CITY OF ALBUQUERQUE

**RE: Lot 24 Block 6 Unit 18 SAD 228
6515 Pato Rd. NW
Volcano Cliffs Subdivision
Grading and Drainage Plan
Engineers Stamp Date 5/12/2020 (D10D003M24)
Pad Certification Date: 6/30/2020
CO Certification Date: 9/15/2022**

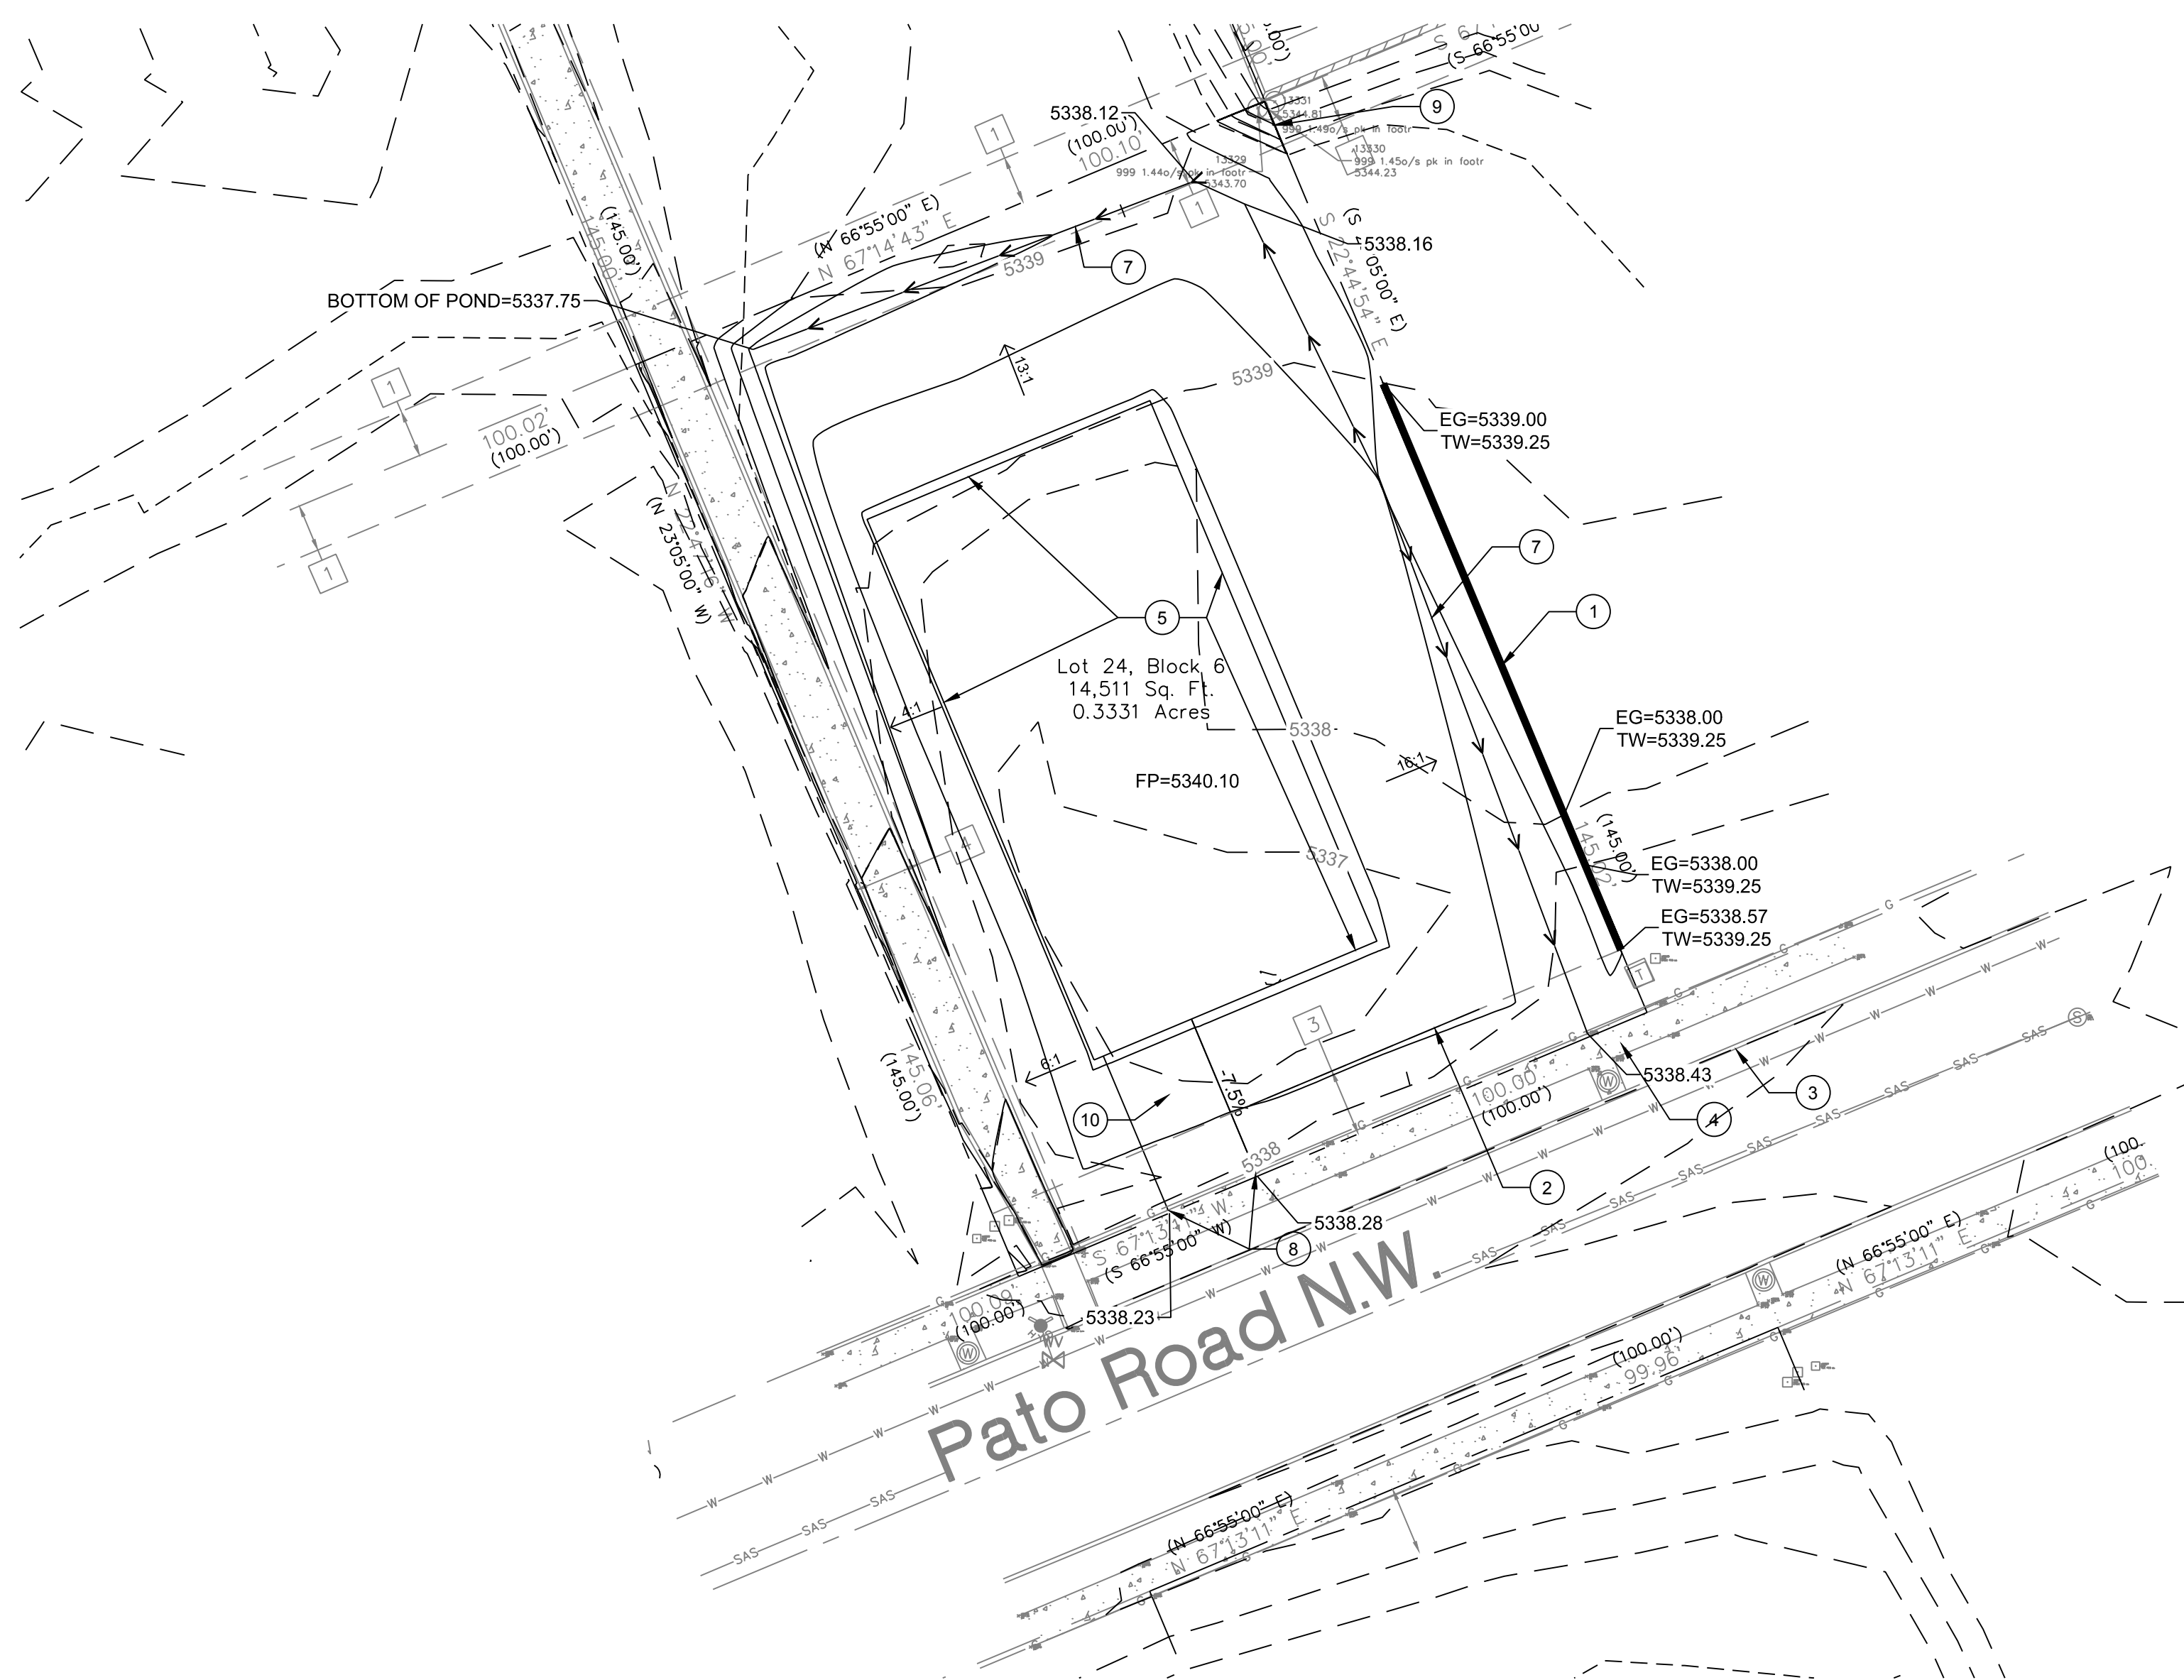
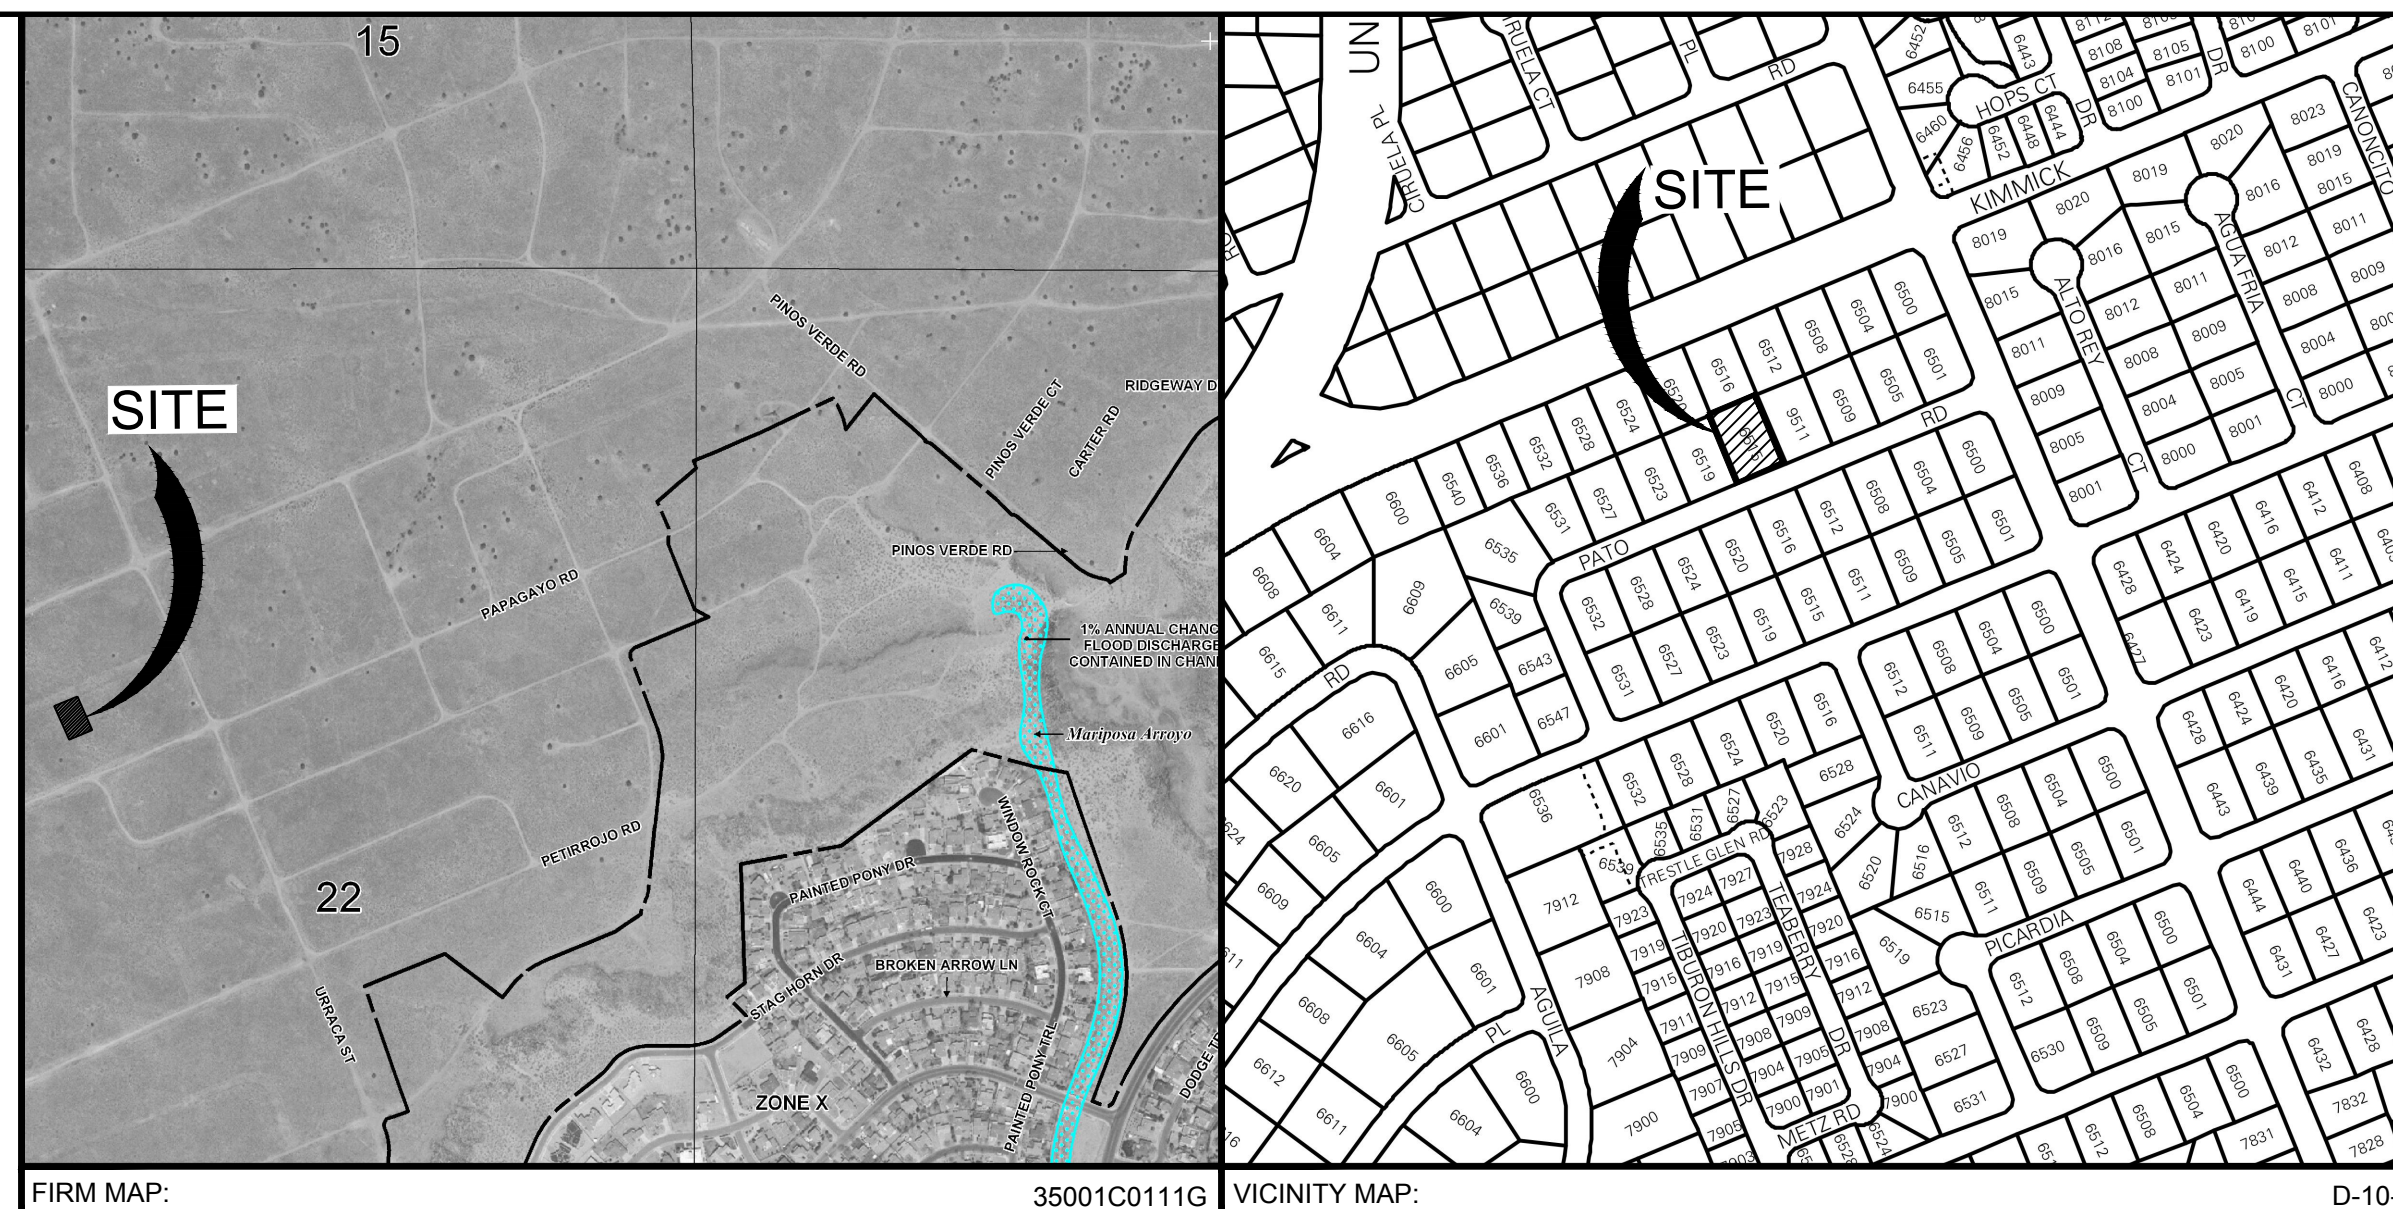
- The public sidewalk must be fixed. There is a missing 4' section and the other two sections are not in the right position.
